**Presumpscot River Place**

**From:** Jay Reynolds  
**To:** port-web:DReynolds@[gorrillpalmer.com]  
**Date:** Thu, Jan 20, 2005 2:24 PM  
**Subject:** PRP III, Lot 1, Review Comments

Drawing Name: Lot 1 Site Layout & Utility Plan  
Project: PRESUMPCOT RIVER PLACE

Drawing Name: **Lot 1 Grading & Drainage Plan**  
Project: **PRESUMPCOT RIVER PLACE**

SHEET NAME  
**ELEVATIONS**

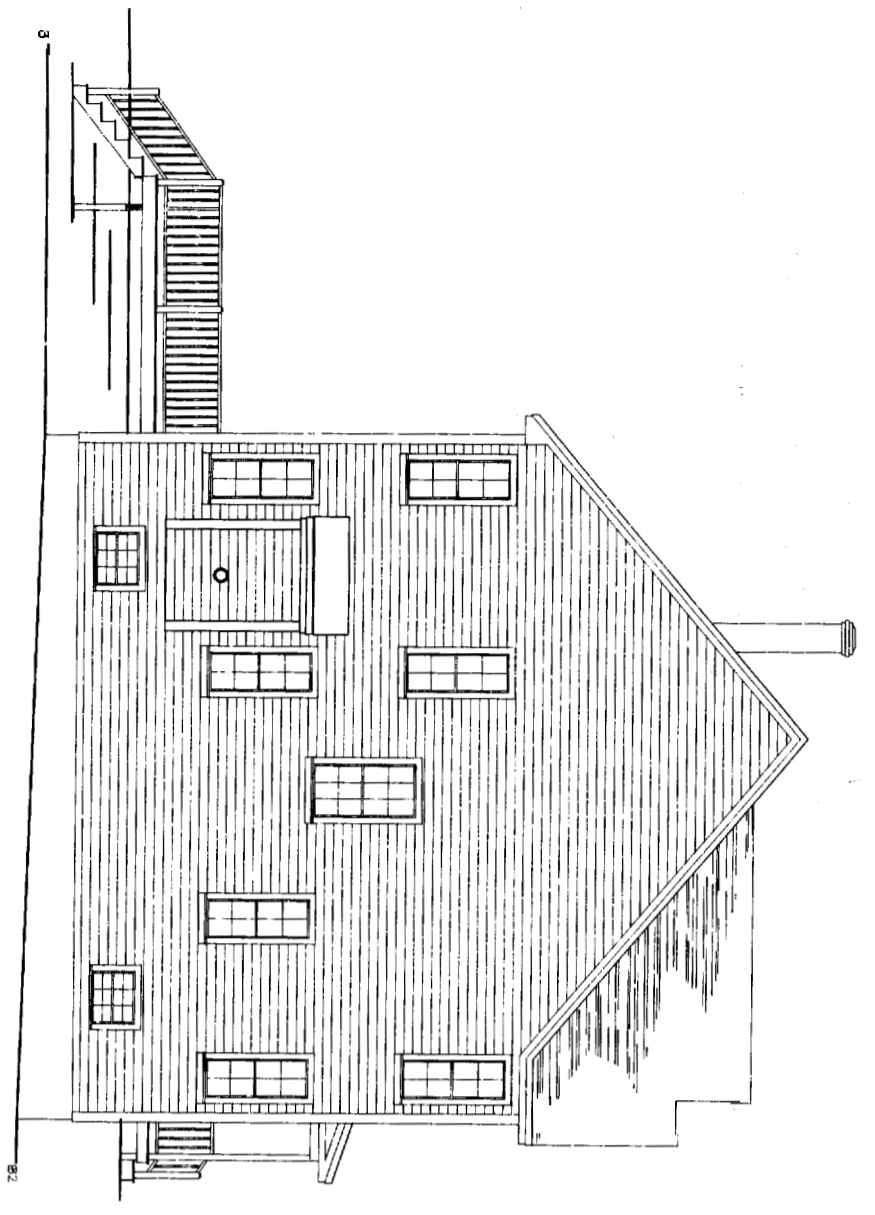
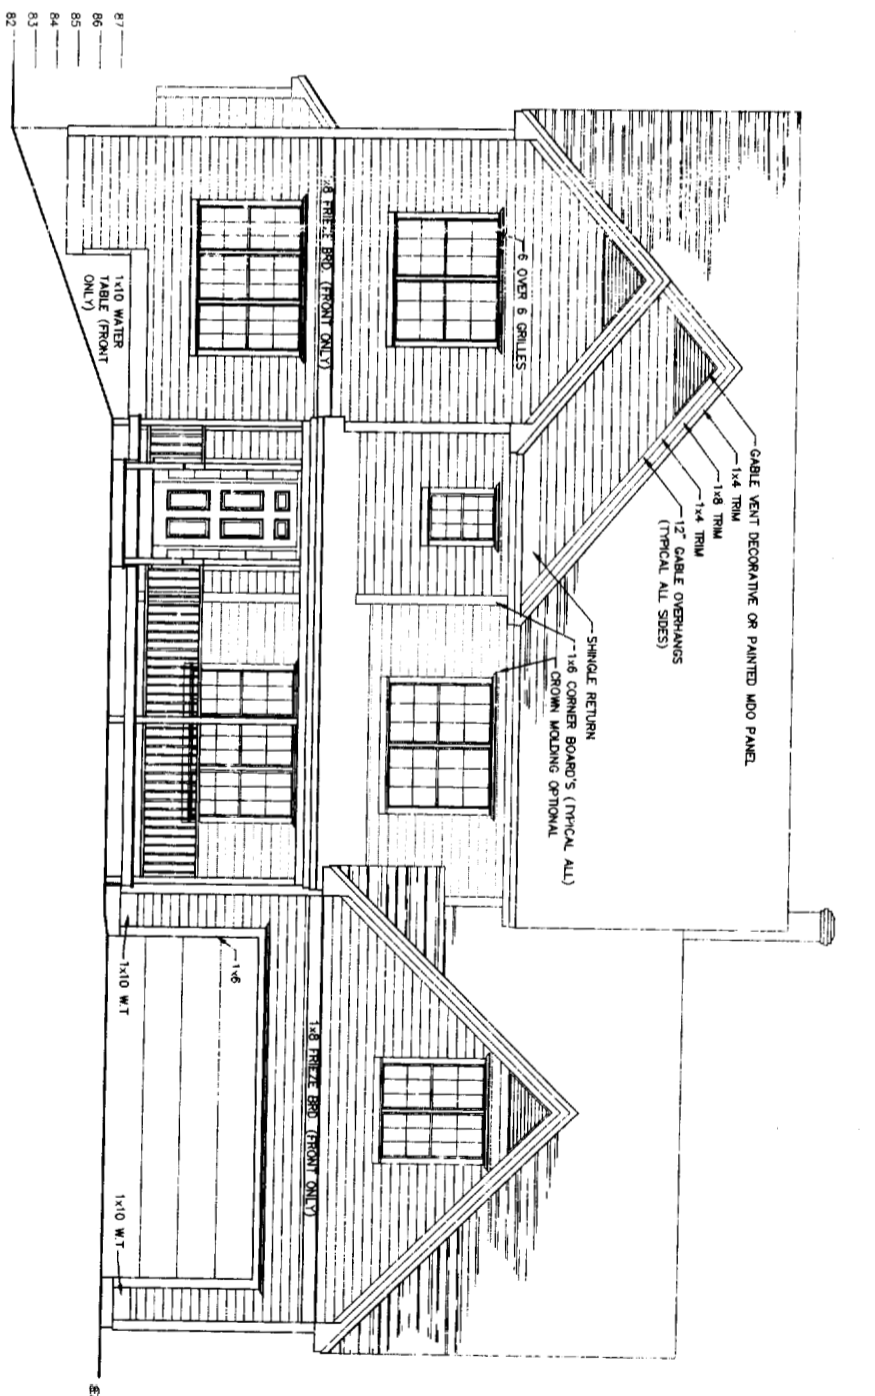
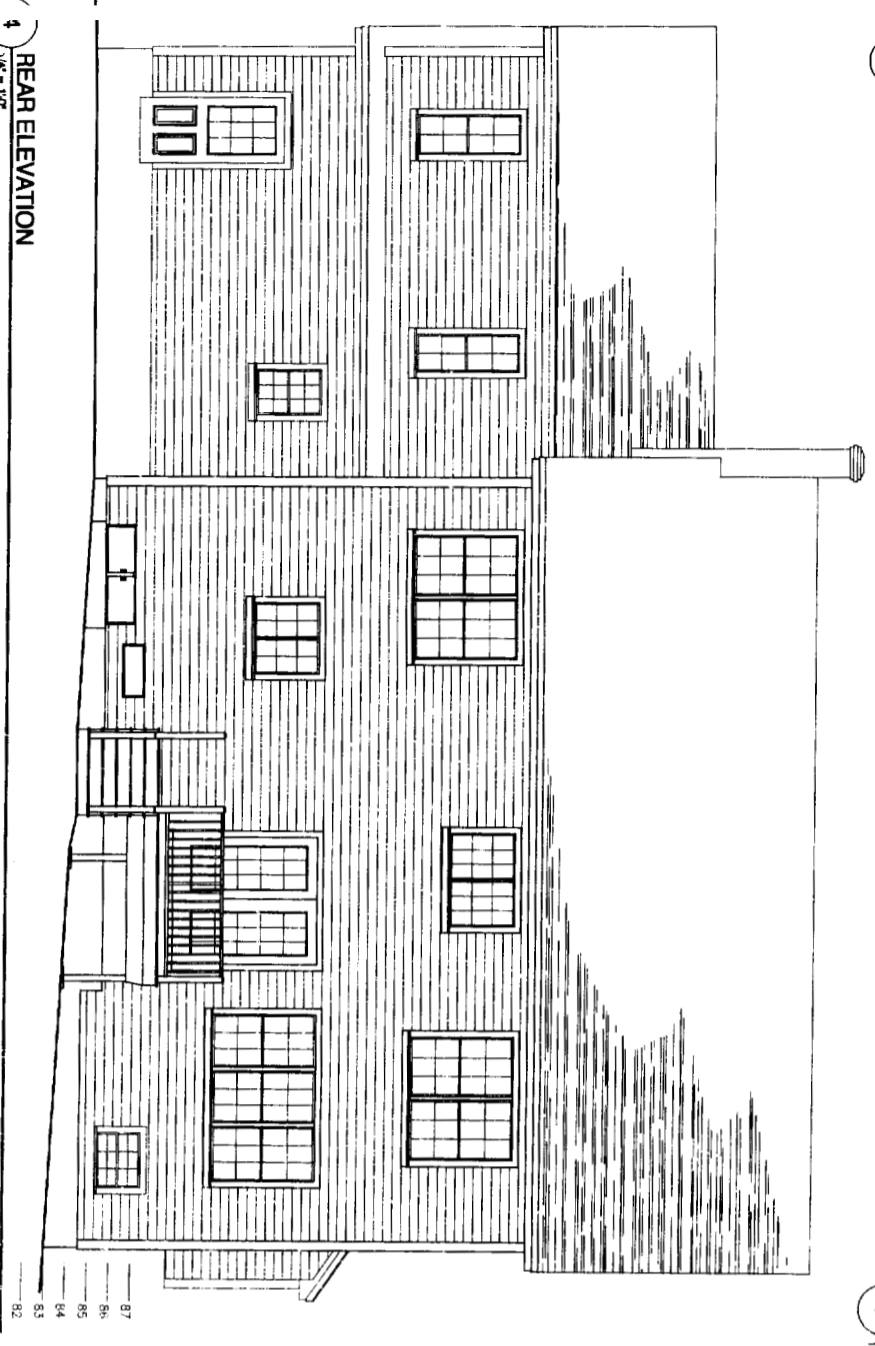
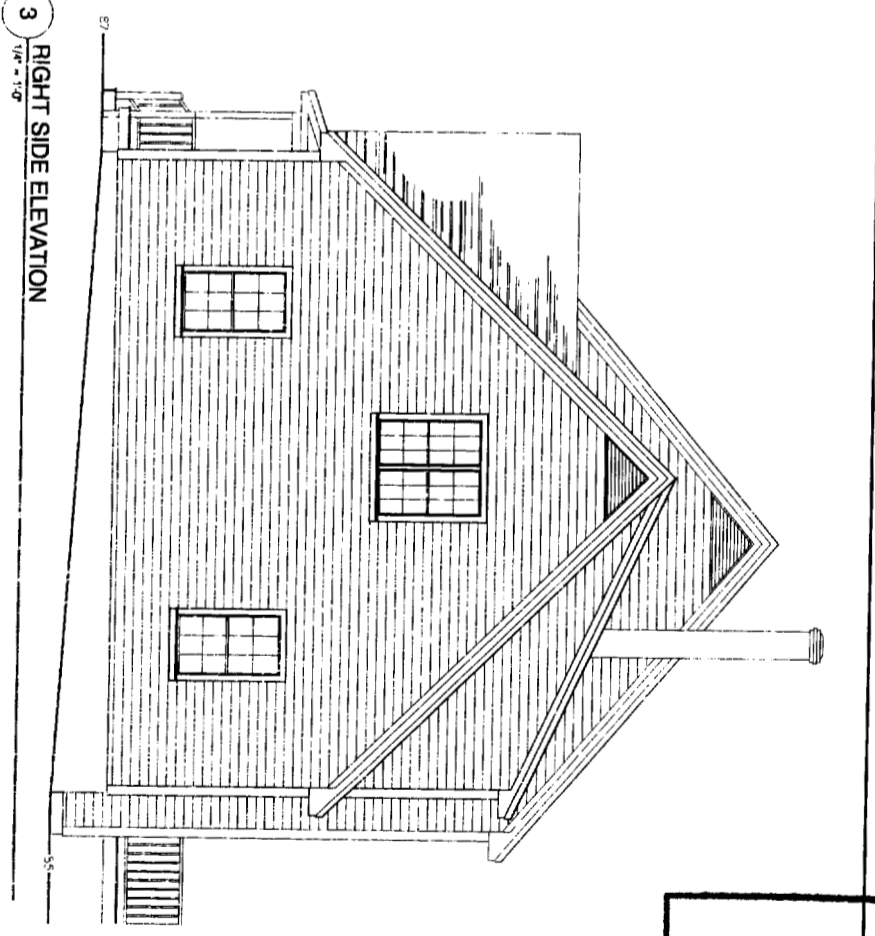
1. Site plan grading doesn't match the building elevations: Site plan shows 3-5' of wall showing, according to the grading and FFE. Building

elevations do not reflect this.

1. An updated building elevation will be provided by the applicant, which reflects the proposed grades within the site.
2. As you may remember some of the other lots (Lots 15 & 21) had similar setbacks to the Do not Disturb area. The proposed grades at the building corners are at the same elevation as the existing grades. Impact of the Do not Disturb zone should not be required. It is noted that the Do not disturb zone will be located by the surveyor. Moving of the building would not meet setbacks on the easterly side of the lot.
3. The possibility of a rock wall in the front of the site is not out of the question. Depending on exact condition of the site, this slope will be reviewed in place. Lowering of the finished floor would not be considered, whereas, the foundation drain would need to be longer, or require a pump.

Drawing Name:	Lot 1 Site Layout & Utility Plan
Project:	PRESUMPSCOT RIVER PLACE

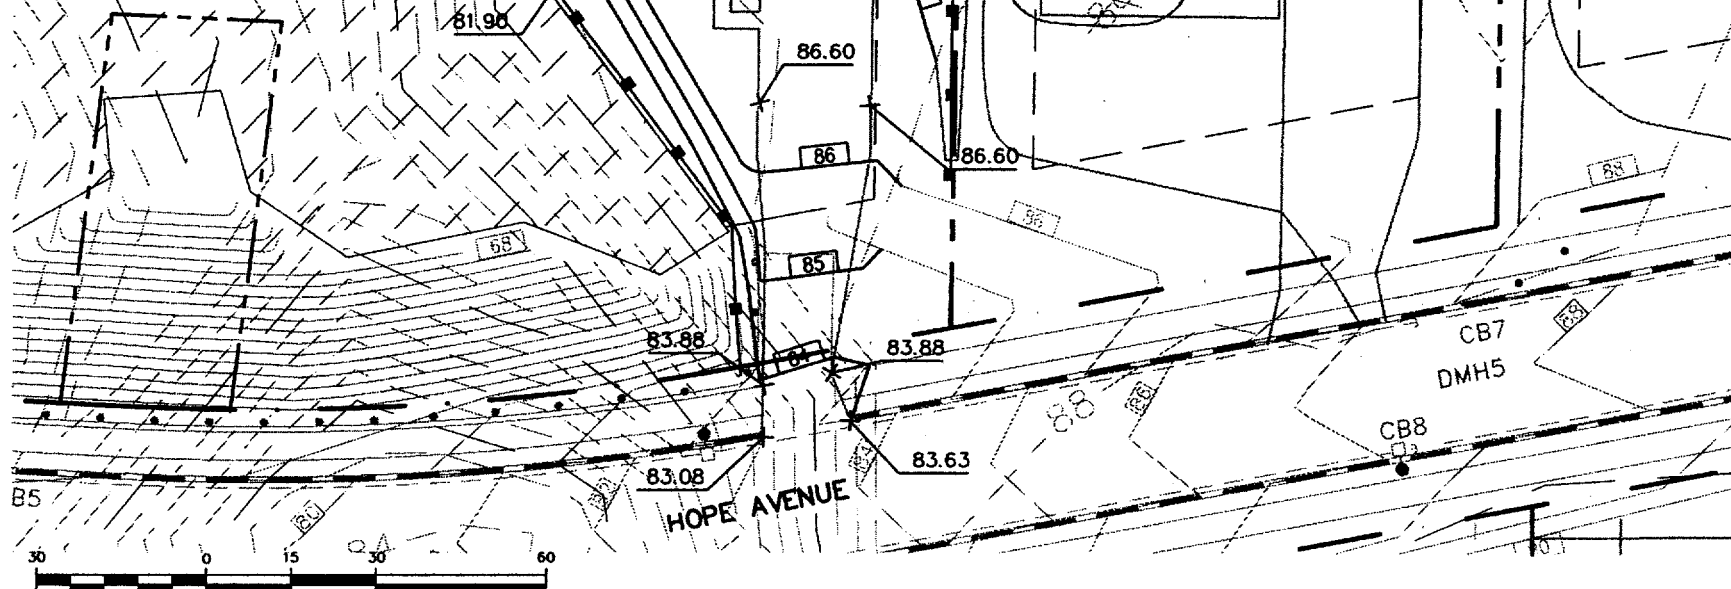
Another item has been noticed. The building falls outside of the building envelope. The subdivision approval (Note 3) states that ".....changes to such area must receive the written approval of the City of Portland Planning Board or Planning Authority prior to commencement of construction and must be recorded in the cumberland county registry of deeds with a reference to the plan book and page for this plan."

This will need to be addressed prior to issuance of building permit.

2. Proximity to undisturb zone: Is there any chance of moving the building easterly so that there is more than 3' between the corners of the building and the undisturb zone? 3 feet doesn't allow for much error during earthwork.

3. 31% sideslope in front yard: has the possibility of a rock wall or lowering the FFE been explored to lessen this sideslope in the front yard?
